MEMORANDUM

Project name: Colvin PRD

PA22-015

Proposal: Planned Residential Development (PRD) and preliminary Binding Site Plan approval to construct 29 single-family detached units on 4.15 acres, utilizing MMC Chapter 22C.090 *Residential Density Incentives*, to increase the base density from 20 to 29-units. Two Administrative EDDS Variance have been requested, including reducing the PRD road ROW width from 50 to 45' and installation of a permanent hammerhead turnaround in lieu of a temporary cul-de-sac

PRELIMINARY ROAD, GRADING & UTILITY PLAN
COLVIN PRD

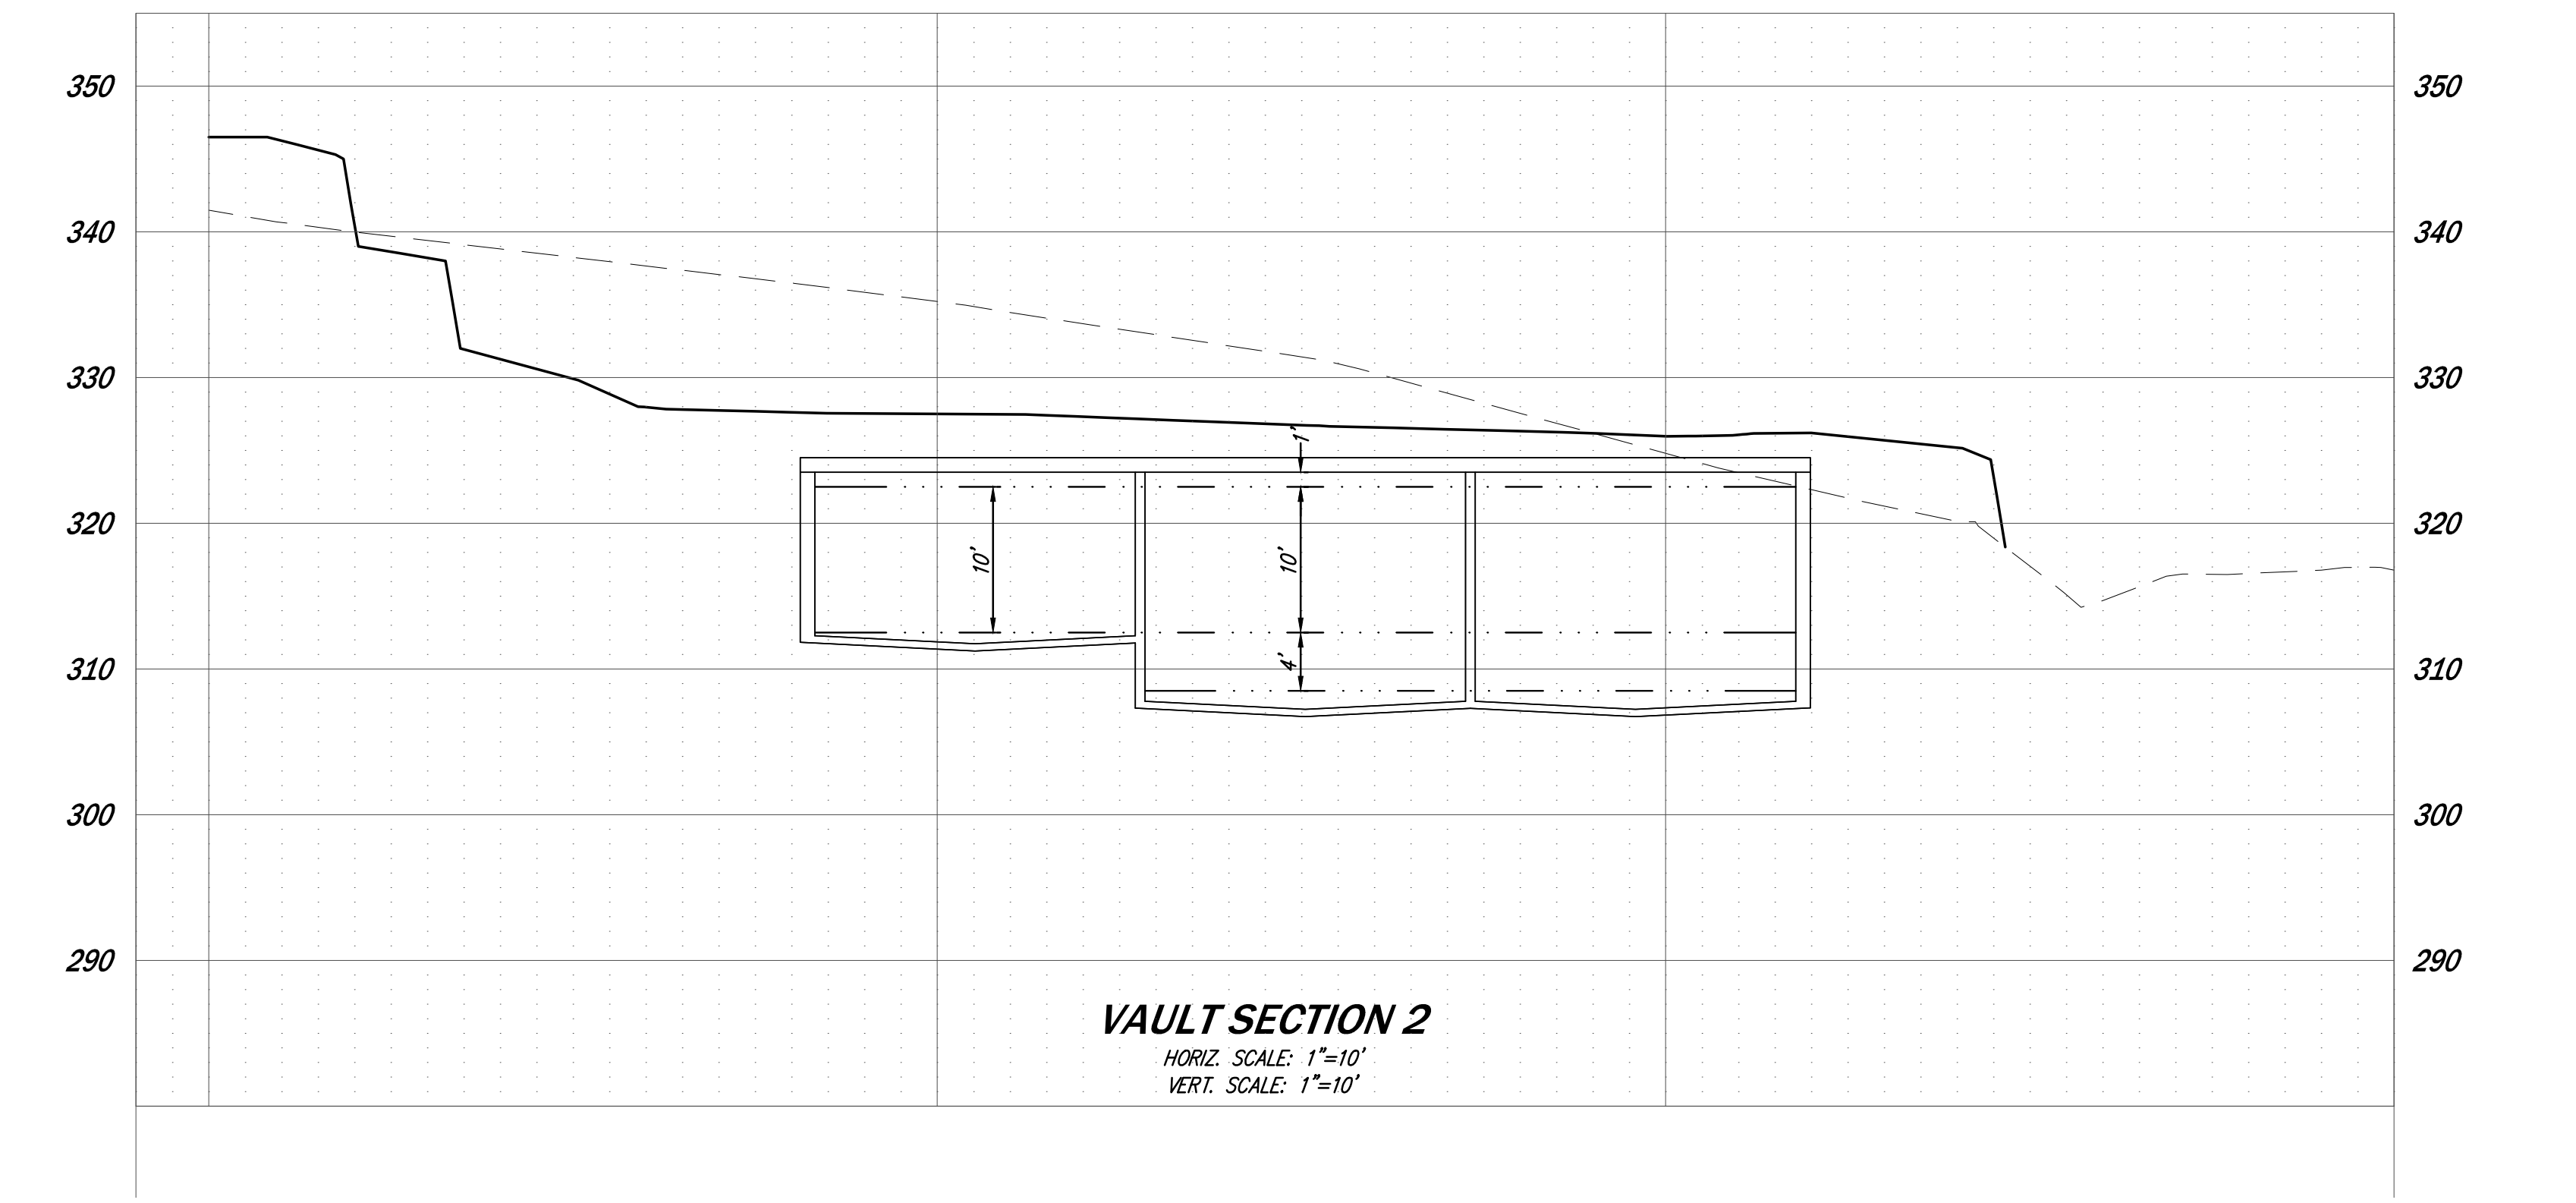
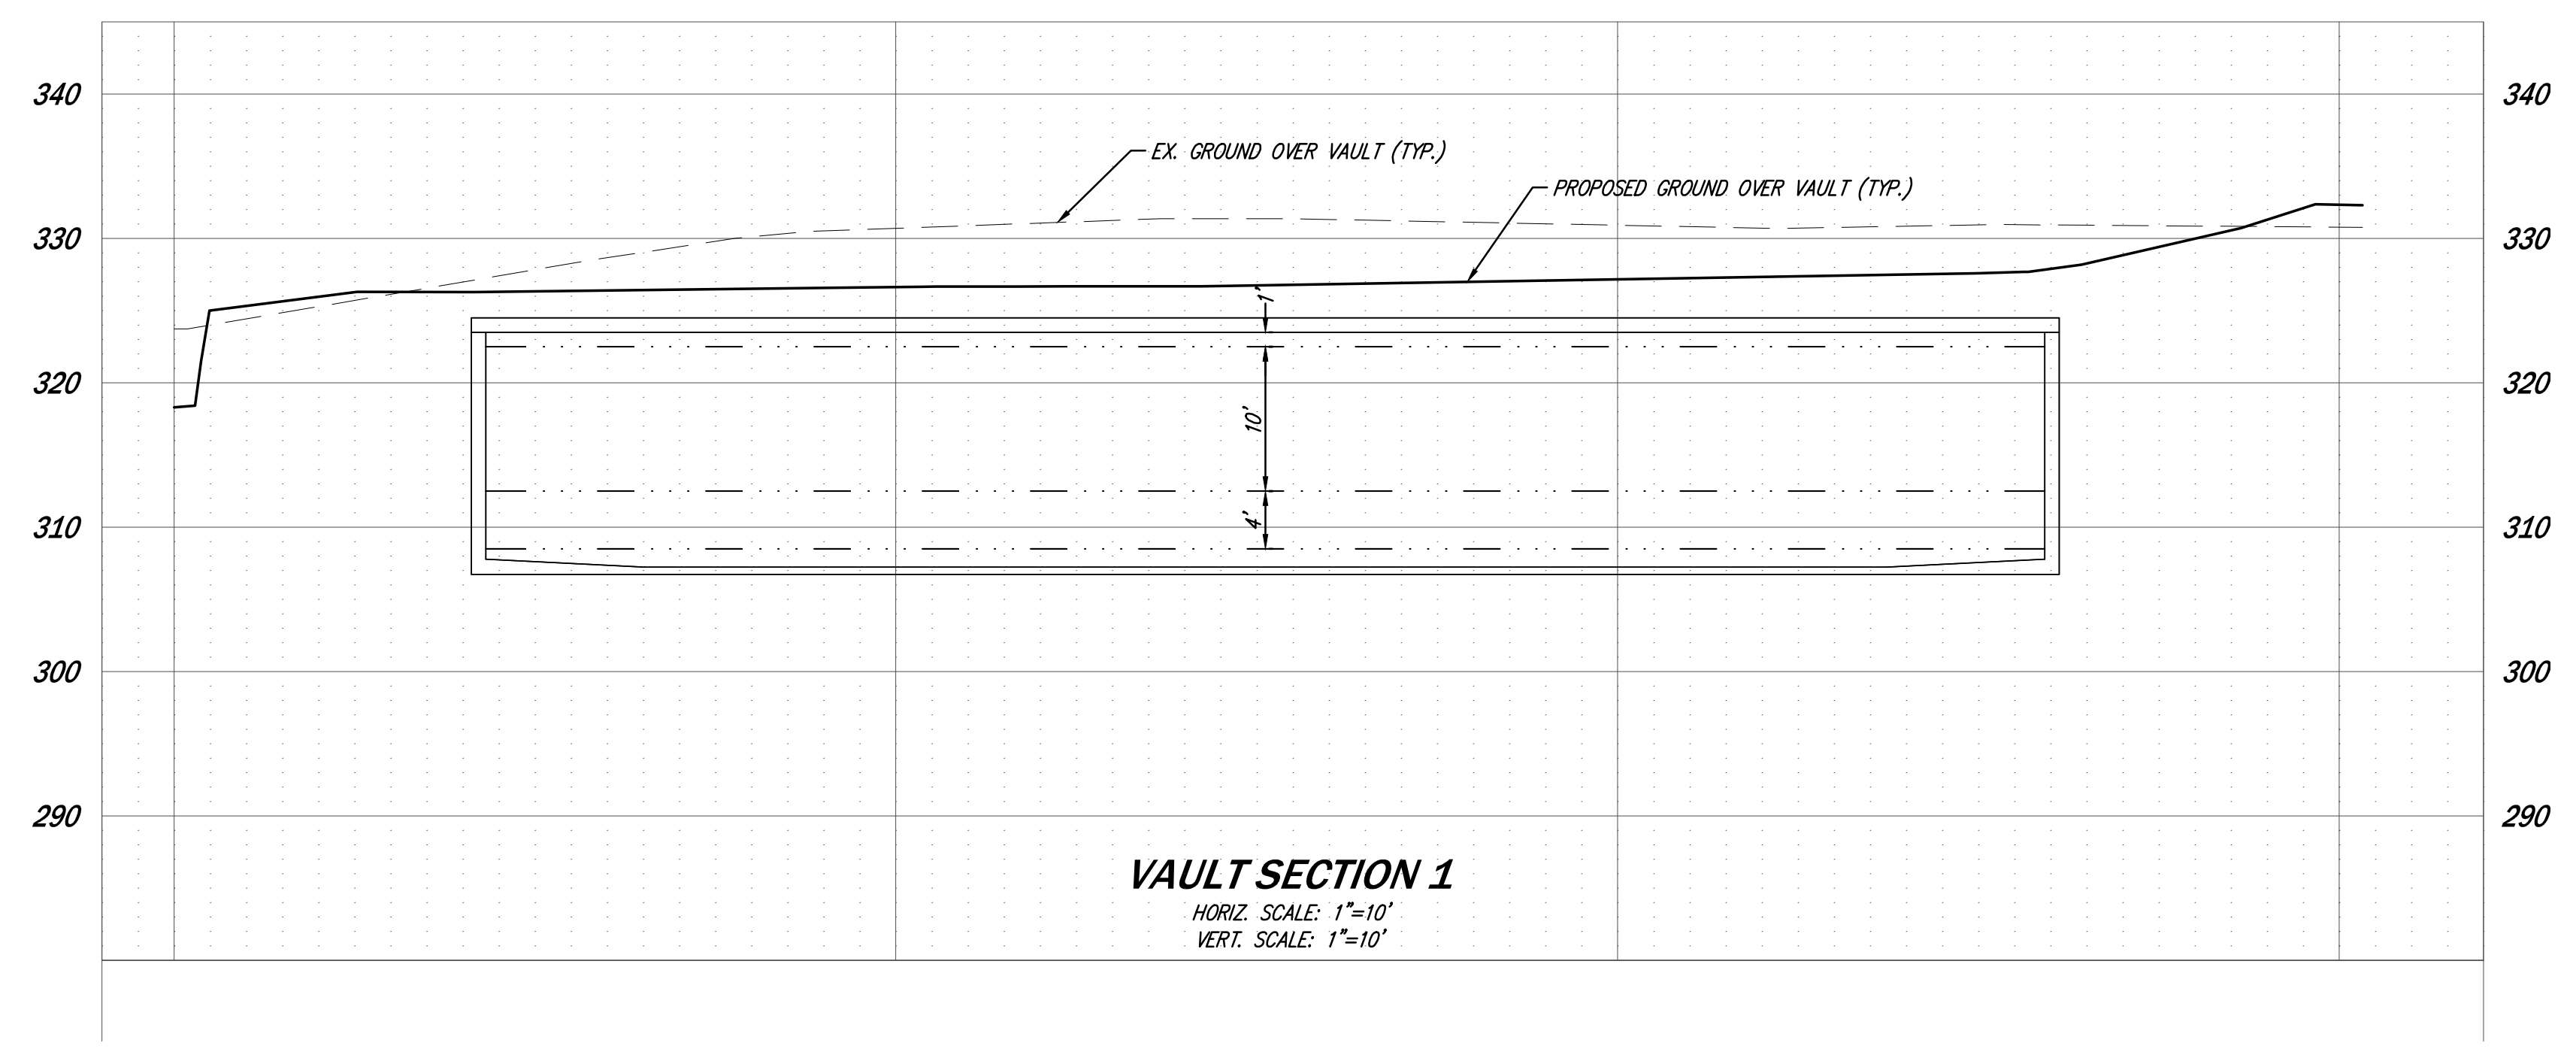
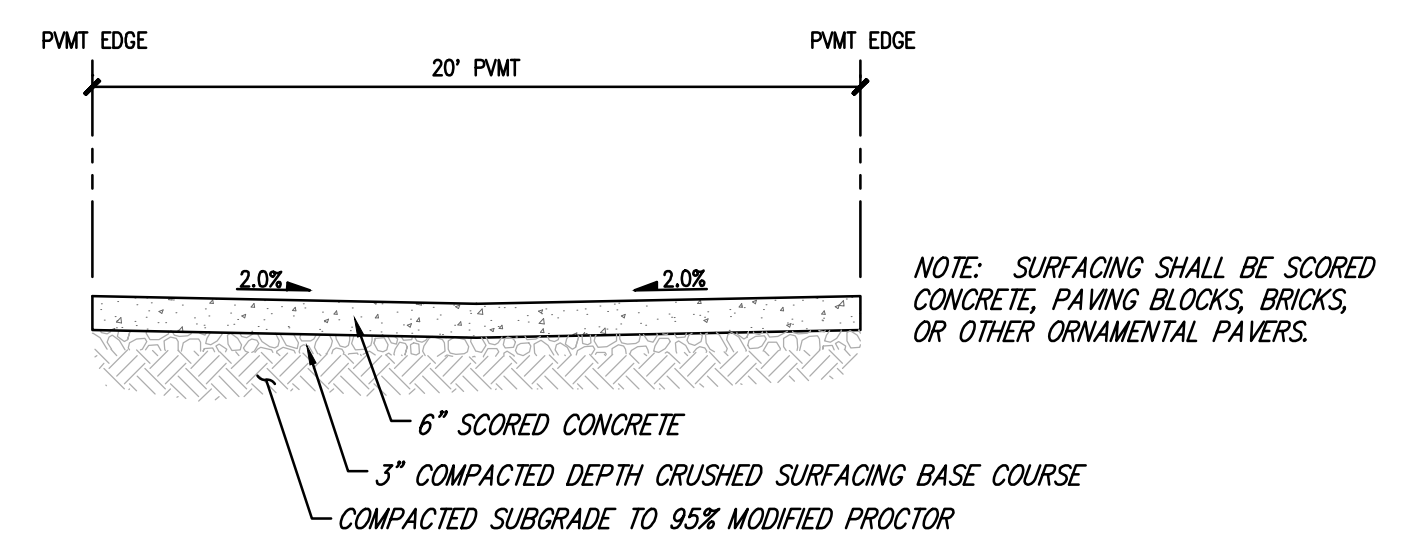
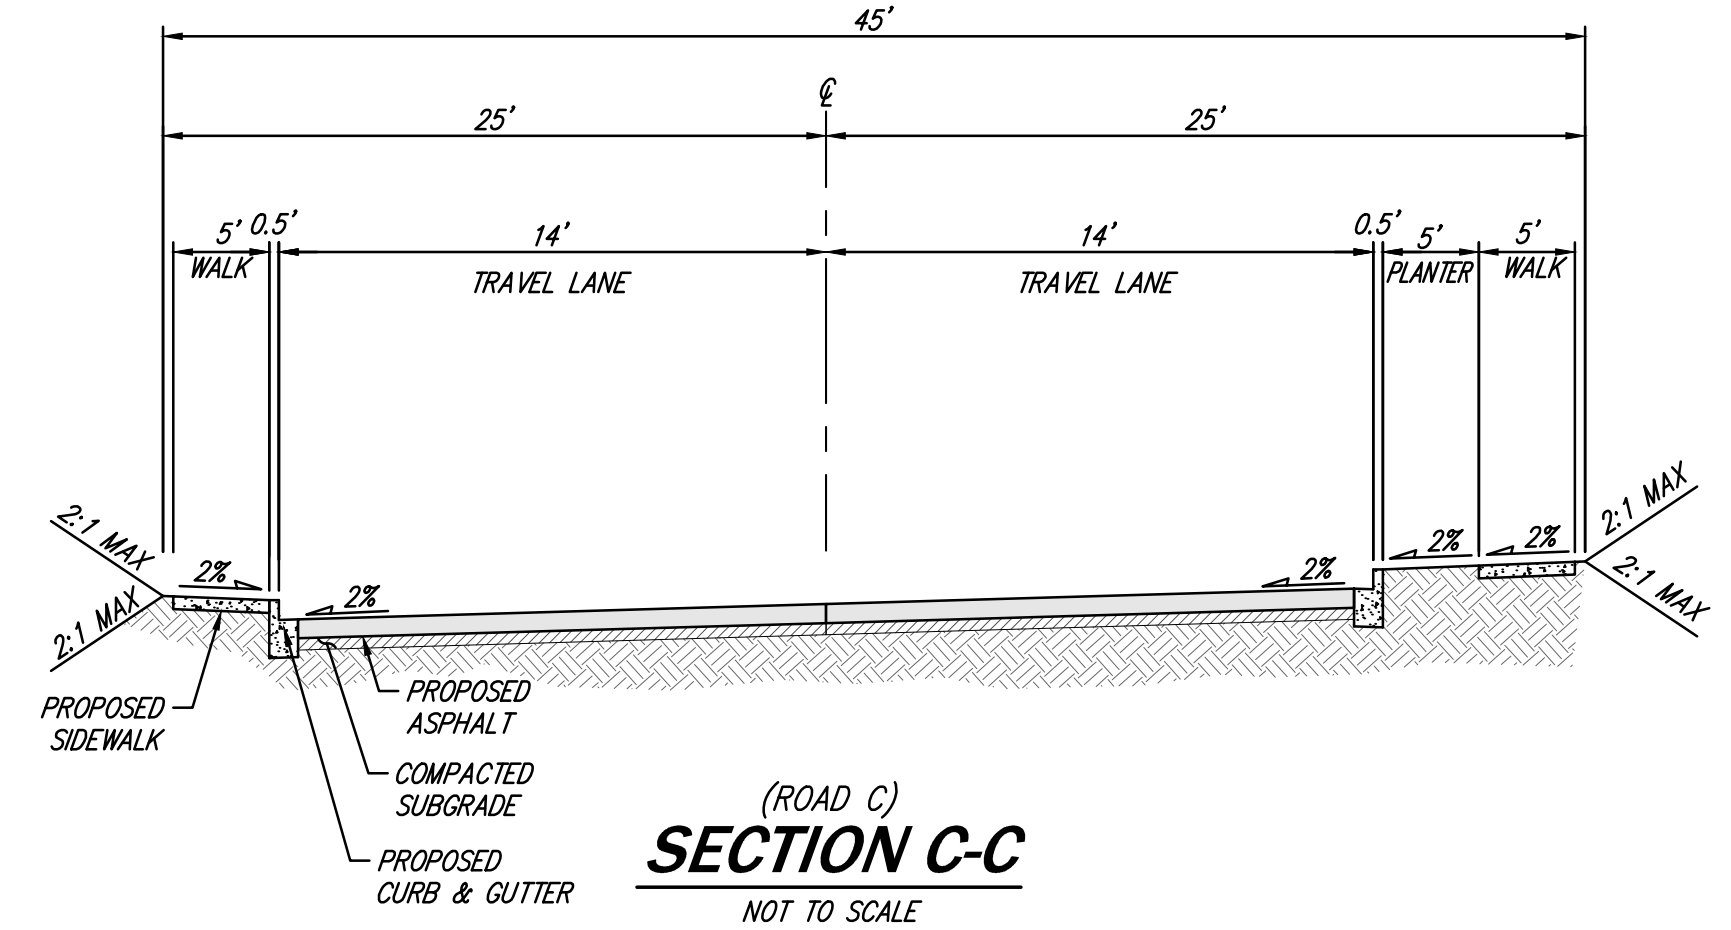
Plans show proposed water main extensions and three fire hydrant locations. Water main extension with approved fire hydrants onsite will be required. Locations appear acceptable.

10. Access planned appears adequate for fire apparatus. Access of 20-28' wide is shown on the plan. A minimum 20 feet wide fire apparatus access road is required. A minimum 26 feet wide fire apparatus access is required in the immediate vicinity of any building more than 30 feet in height for ladder truck operations, and within 20 feet on both sides of fire hydrants.

11. Turnaround provision is required for dead-end access in excess of 150 feet long.
12. The temporary hammerhead turnaround area proposed appears adequate. Turnarounds shall comply with city standard plans.

- a. TIA is acceptable.
- 3) Full residential roadway cross-section shall be required upon all internal development public roadways.
 - a. Sidewalk and landscape strip shall be required upon “Road B”.

- a. No pavement markings shall be necessary.
- b. Signing:
 - i. Street name signs at all intersections.
 - ii. No Outlet sign upon Road B west of Densmore RD.
 - iii. Dead End sign on Road C south of Road A.
 - iv. Type IV Object markers and Future Roadway Connection signs at end of Road A and Road C.
